**ANNEXURE 1 – RESPONSE TO SUBMISSIONS  
ALTITUDE ASPIRE – MP09\_0166**

**DEPARTMENT OF PLANNING**

BROADWATER PARKWAY
LAYOUT

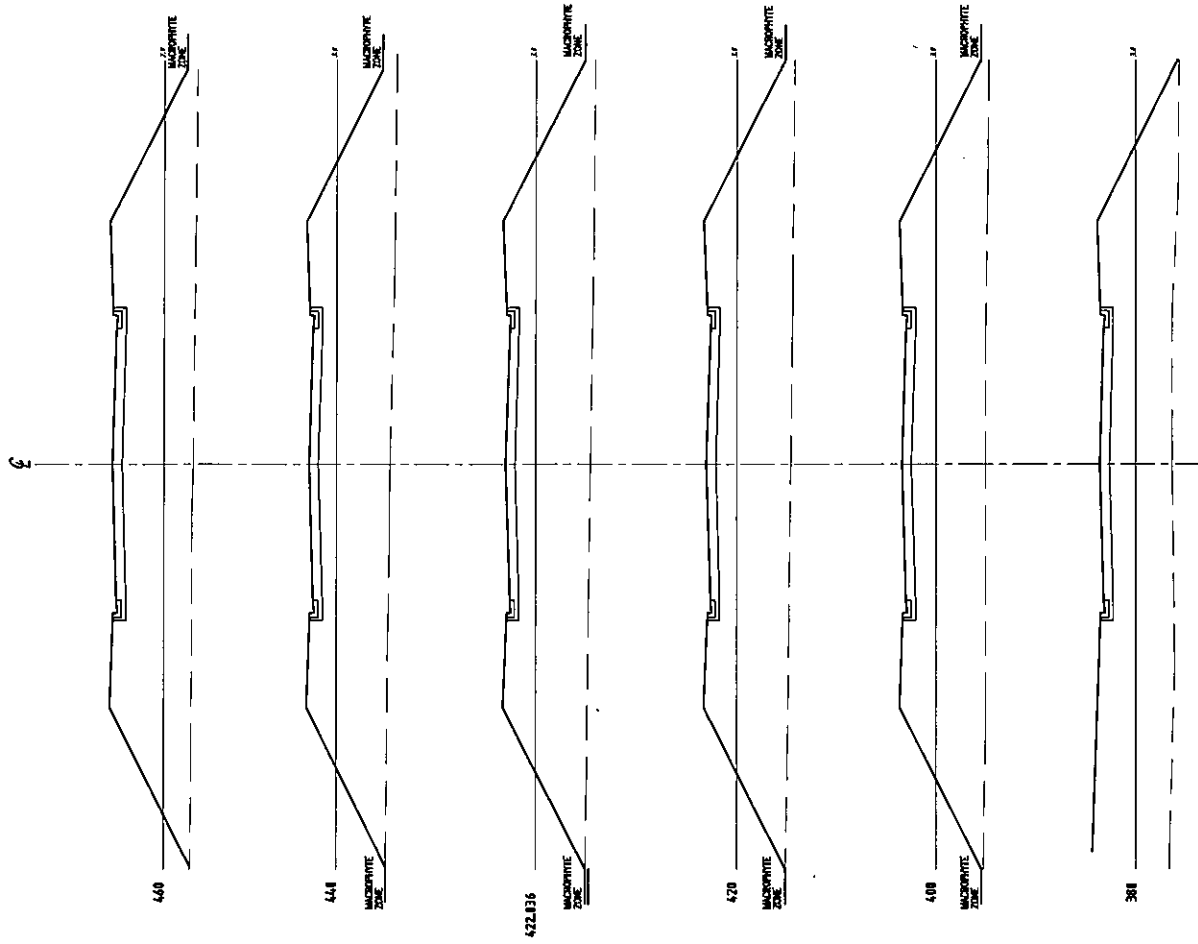
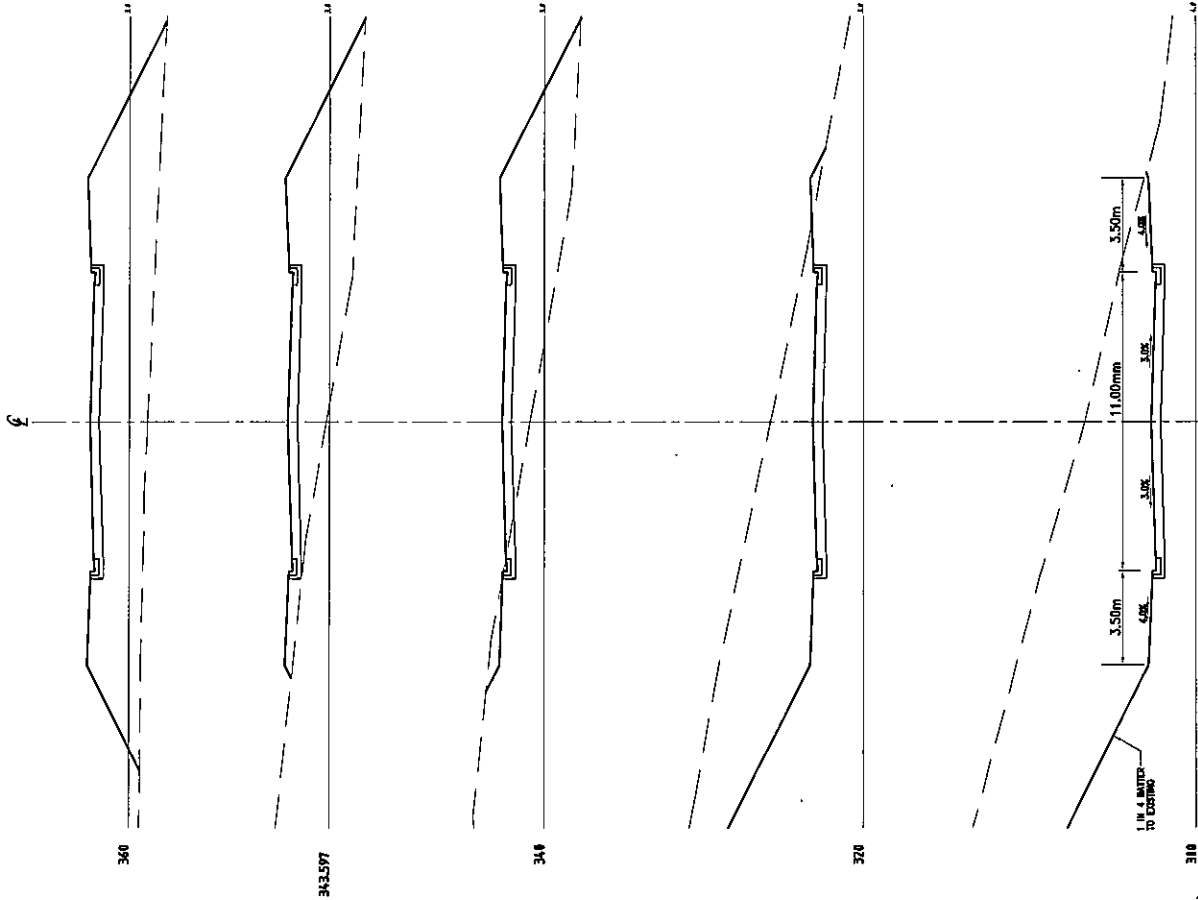
- **Broadwater Parkway** -The construction of this road (and its funding, land acquisition etc.) is fundamental to Phase 2 (Stages 6-11) occurring. The proposed alignment of the Broadwater Parkway road corridor to be reserved across the site will have significant bearing on the development footprint for this proposal, and will have implications for the alignment of the Parkway across the rest of Area E. The Department notes there are a number of options tabled for the proposed route/alignment of Broadwater Parkway. Justification for the preferred route will be required (environmental constraints, land acquisition, reduced impact on proponent's land, road design considerations, SoC etc.). While it is unreasonable to expect the proponent to assess the ecological impacts and otherwise for the entire alignment of Broadwater Parkway, the Department recognises that there are constraints external to the site boundary of this application that must be considered. The proponent must ensure that the road corridor proposed to be reserved in this proposal is entirely consistent with the road corridor alignment for Area E as a whole. The Department supports Council's request for inclusion of the current DCP alignment (refer Figure 1 of Council's submission) within this proposal as the benchmark road alignment. This alignment would appear to avoid the majority of environmentally sensitive areas (SEPP 14 wetland buffer, freshwater wetland EEC, Lowland Rainforest EEC etc.) and provide a better solution - however more assessment should be completed in this regard.

- o The Department also notes that the proponent's proposed road alignment through the 7(a) Environmental Protection (Wetlands and Littoral Rainforests) zone is inconsistent with Council's LEP in that alternative road alignments are presently available through the 2(c) Residential (Urban Expansion) zone and therefore must be considered.

- o **SEPP 14 buffer** currently includes the proposed Broadwater Parkway road reserve and embankment, stormwater treatment ponds, and a transmission line easement and lies at the bottom of a steep slope. Alternative road designs have been put forward by Council that avoid environmentally sensitive areas and environmental protection zones. For a greenfield site, there is no justifiable reason for not considering alternative road locations outside these sensitive areas. The Department would prefer to see land reserved for Broadwater Parkway removed from these areas.

- Notwithstanding the above, the final Altitude Aspire Project Application has been amended to incorporate Broadwater Parkway within the 2(c) zoned land and a small section towards the eastern edge of Altitude Aspire within the 7(a) outer 50m buffer zone, generally in accordance with Figure 2.2 Indicative Structure Plan of the adopted Development Control Plan, Section B24.

The location and design of the Broadwater Parkway has been amended after significant assessment of alternative routes (including ecological assessment of the site and surrounding lands) and detailed consultation with Tweed Shire Council.

The alignment now avoids environmentally sensitive areas (FIGURE 10) and, for the most part, the environmental protection zone (FIGURE 11 of **Annexure 9**).
